**Alesco Senior College**  
**27 Chapman Street, Charlestown**  
**Access for Persons with a Disability**

The following accessibility statement has been prepared to accompany the the Environmental Impact Statement (State Significant Design DA process).

Figure 8 | Proposed internal alterations and demolition works (Source: Applicant's EIS)

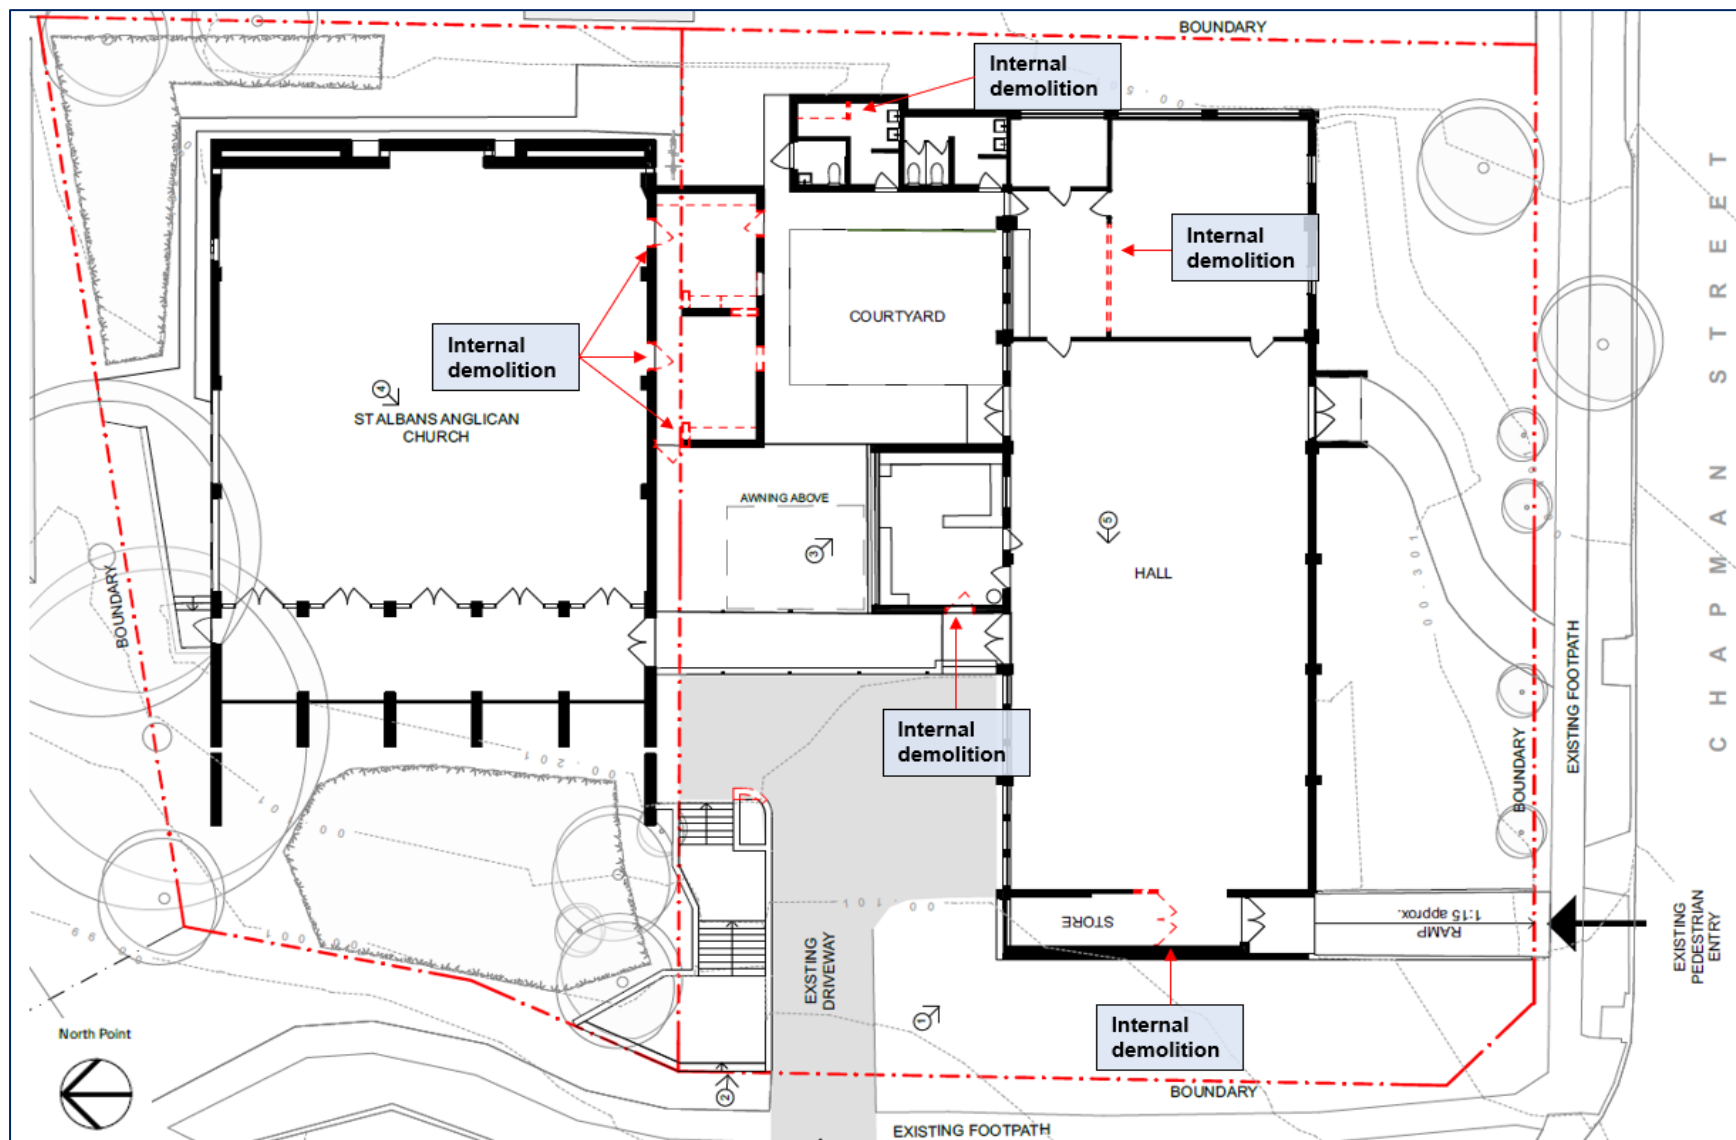
**As part of the upgrades works, a ramp will need to be provided for access from the accessible carparking and the Break-Out Area.**

We recommend that the doorways highlight in pink (Figure 4) be upgraded to offer a step ramp or similar for access throughout the college. This will maximise accessibility throughout the various break-out and courtyard areas and also offer a link to the accessible car parking area.
